## **AQUIND Interconnector**

### **Application by AQUIND Limited for an Order Granting Development Consent**

#### **Local Impact Report**

#### **Havant Borough Council**

Order Limits including
Onshore Cable Corridor
Section 1

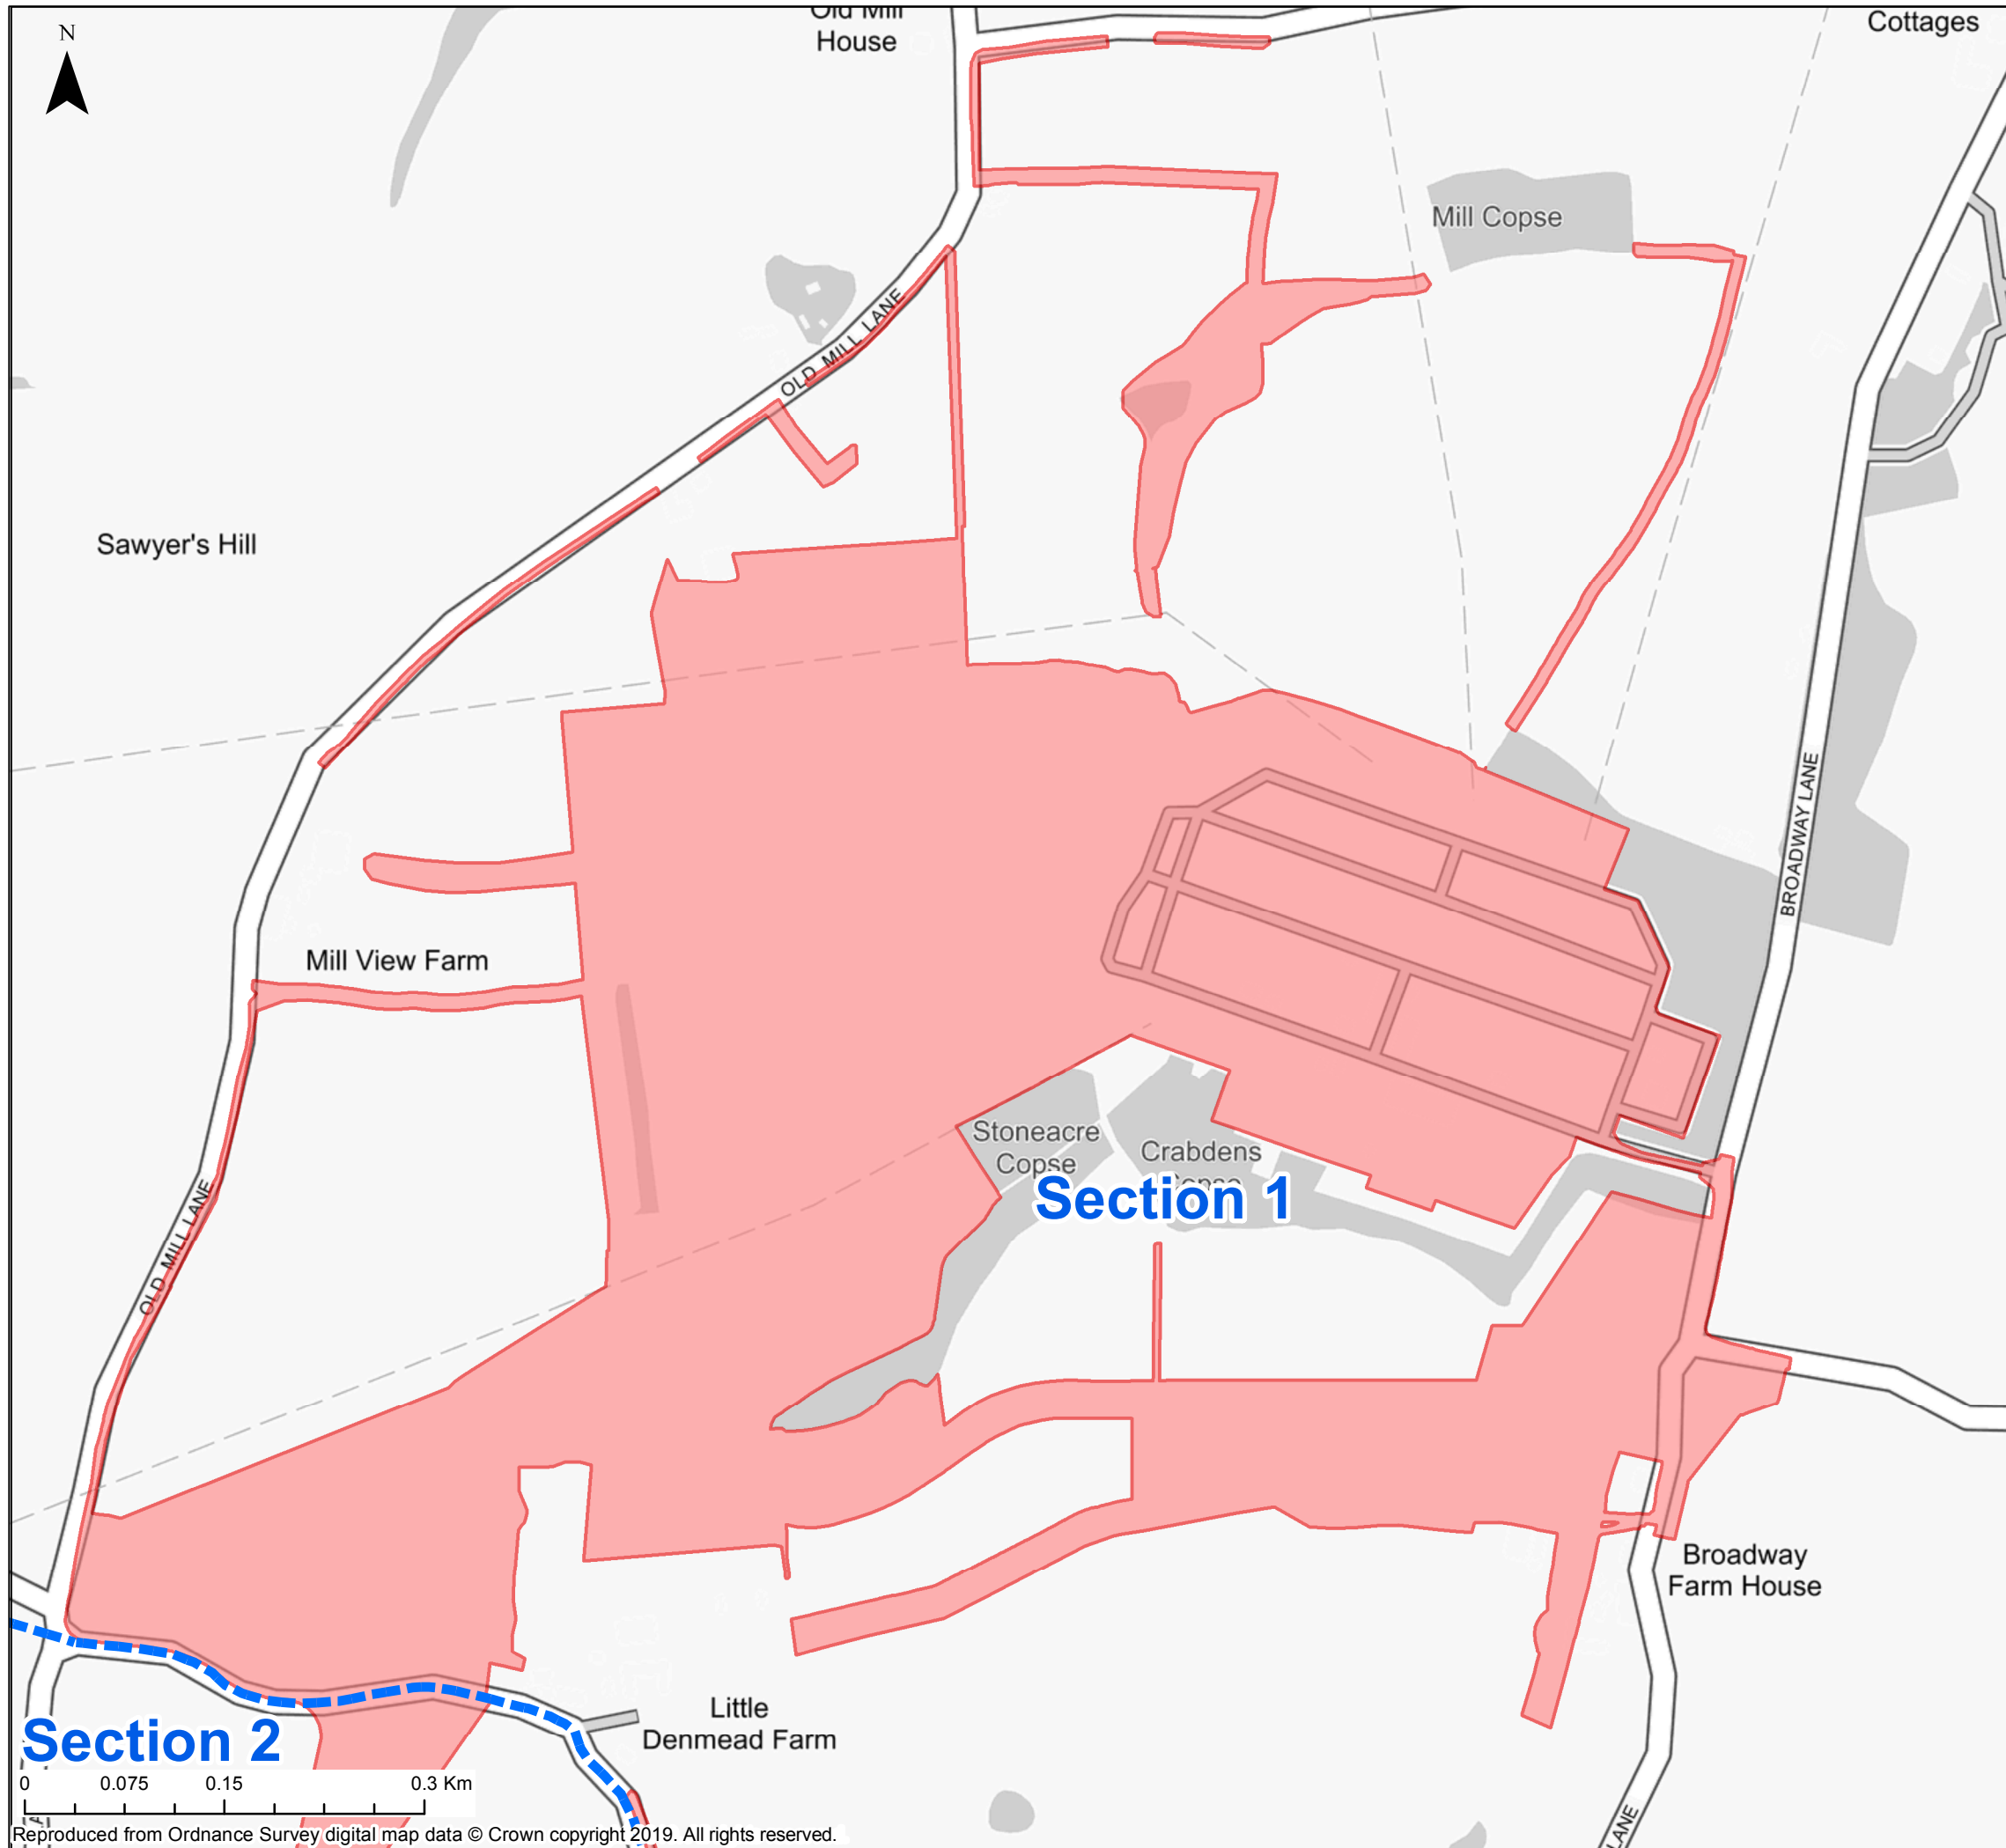
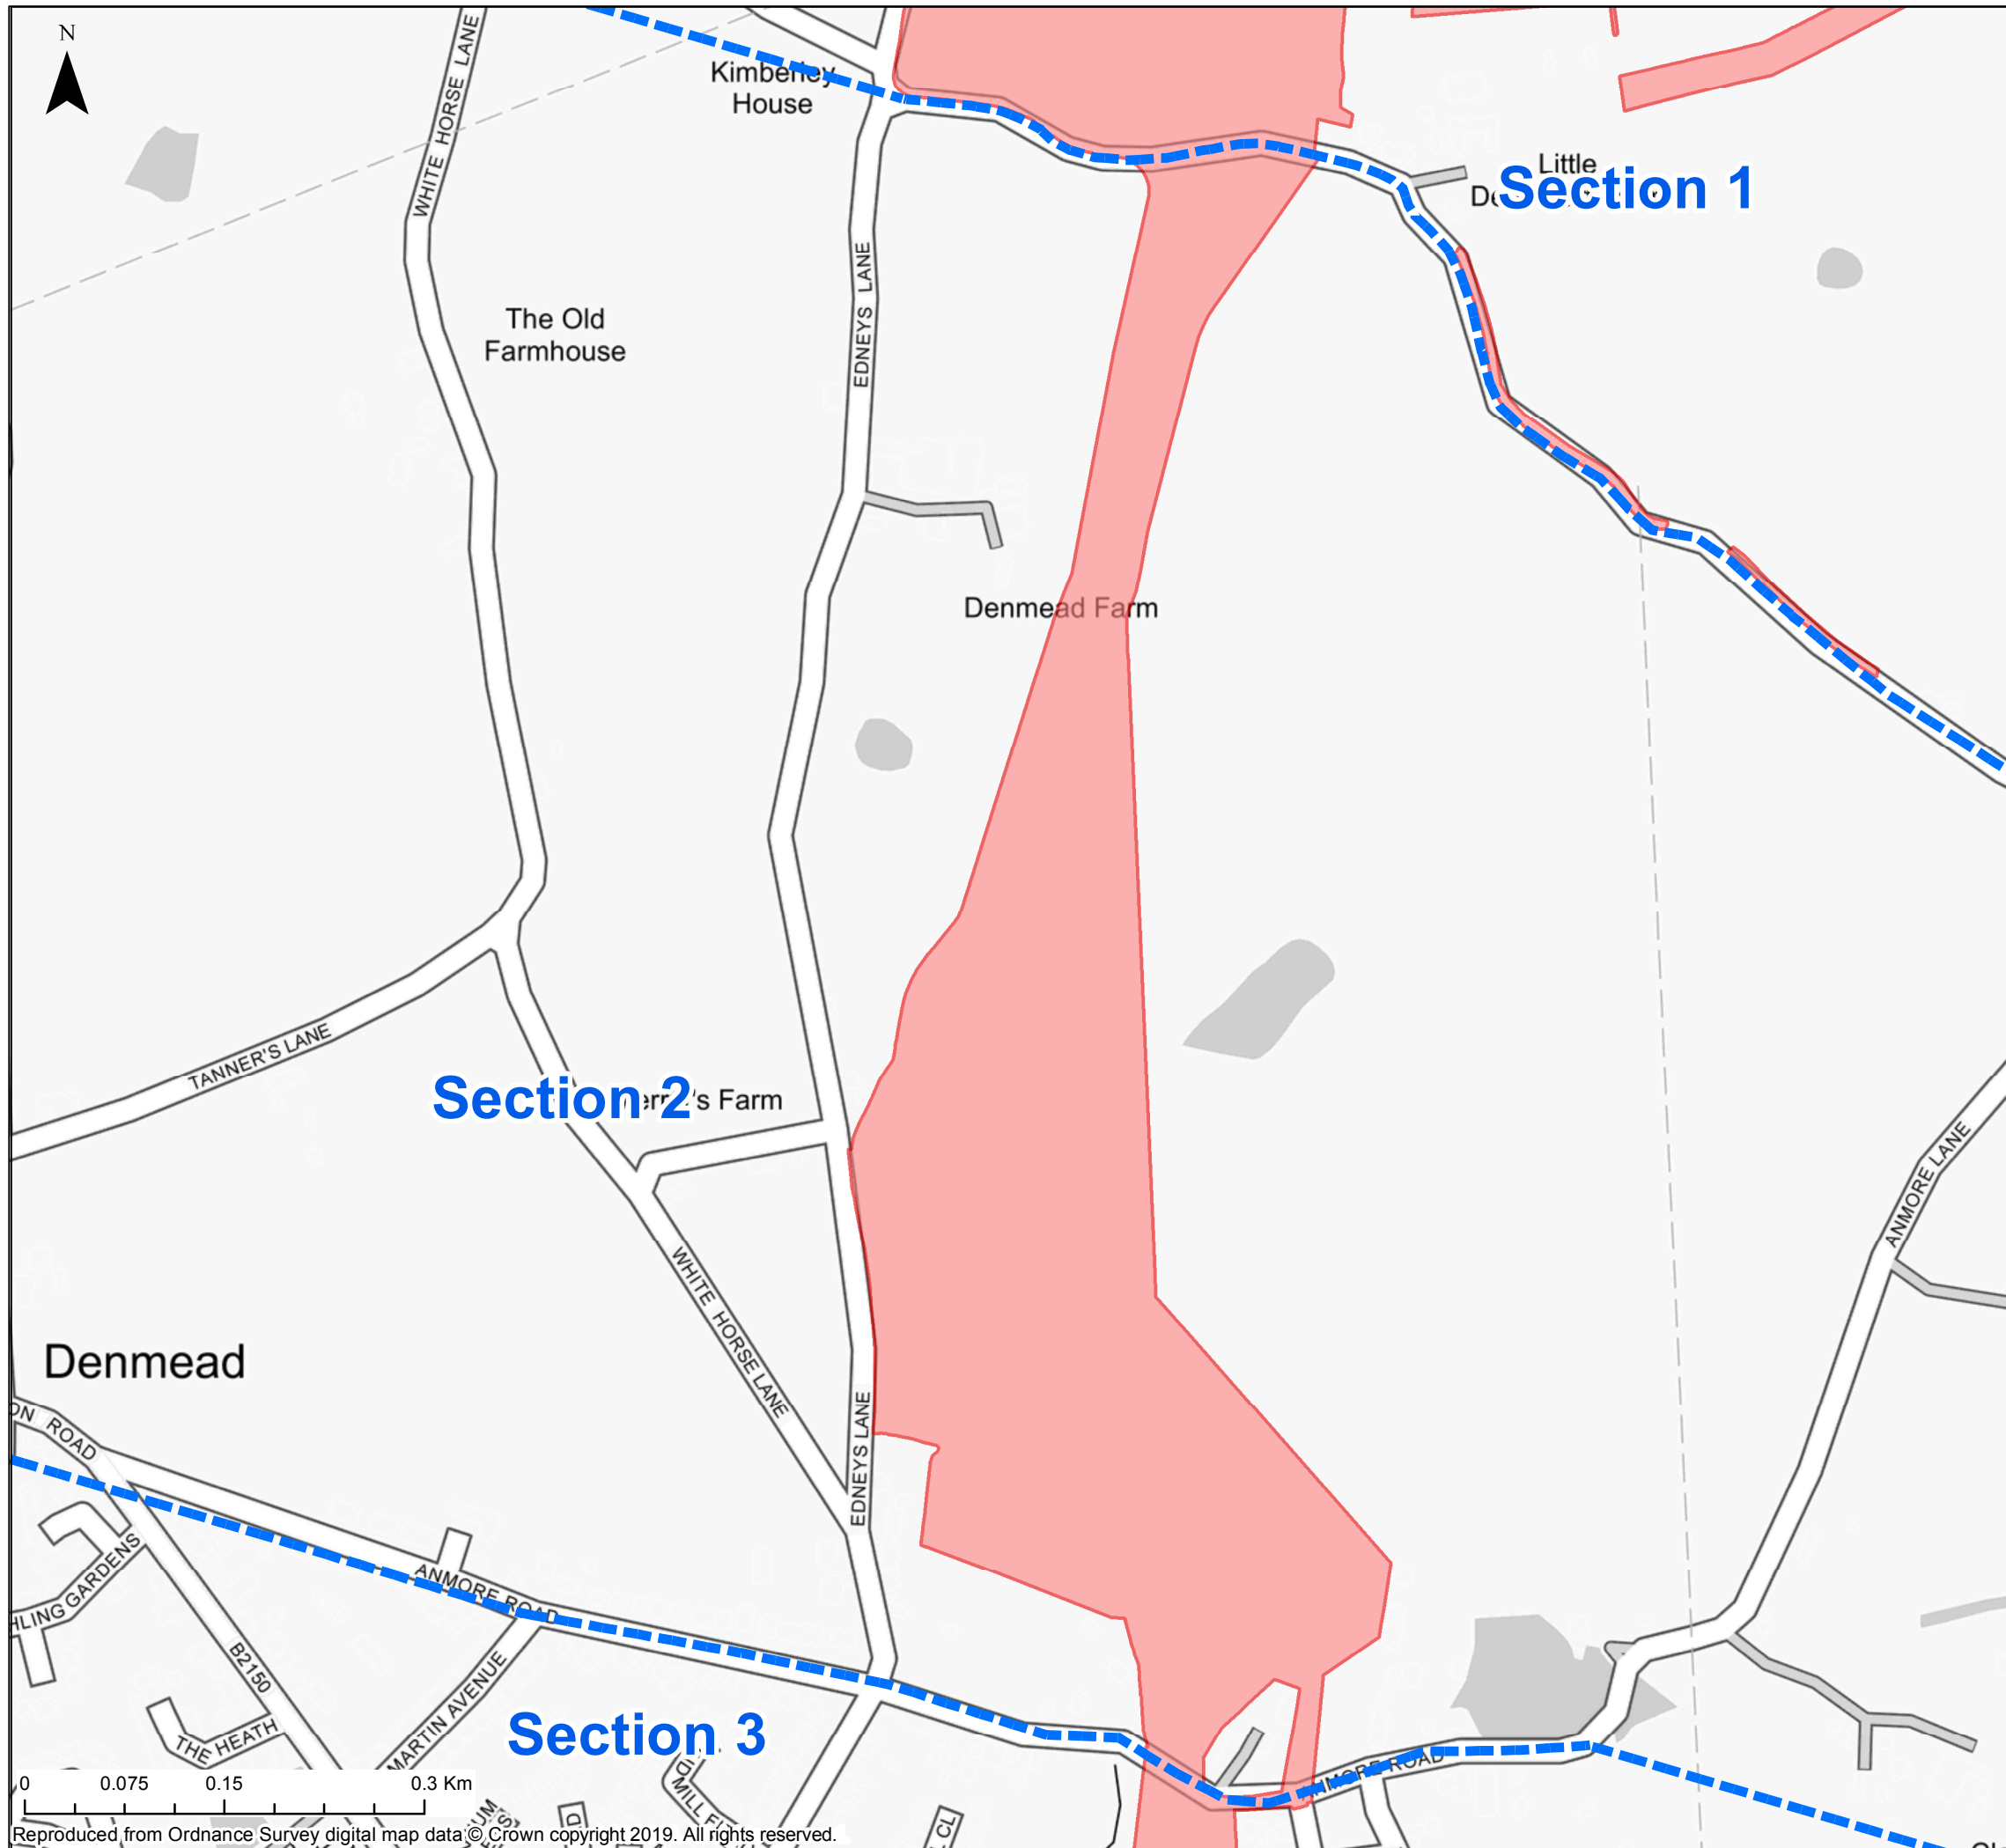
8. The proposed route of the cable along the highway network within the administrative control of Hampshire County Council is shown on sections 1-4 of the onshore cable corridor plans. This brings the cables from the proposed converter station site at Lovedean down to the Portsmouth City Council boundary at the A3 London Road (south of The Dale). The route primarily runs along the A3 corridor and B2150, which are highly trafficked, important priority bus routes, and play a key role within the local network. The cable route corridor in this area caters for the bus 'Star' routes 7 and 8 between Portsmouth and Waterlooville which is a key access facility to Queen Alexandra Hospital and Portsmouth's employment areas.

16. A plan showing the highway boundary overlaying the order limit should be provided to enable a clear understanding of the highway land affected. This can be obtained from HCC's Asset Information Team [assetinformation@hants.gov.uk](mailto:assetinformation@hants.gov.uk)
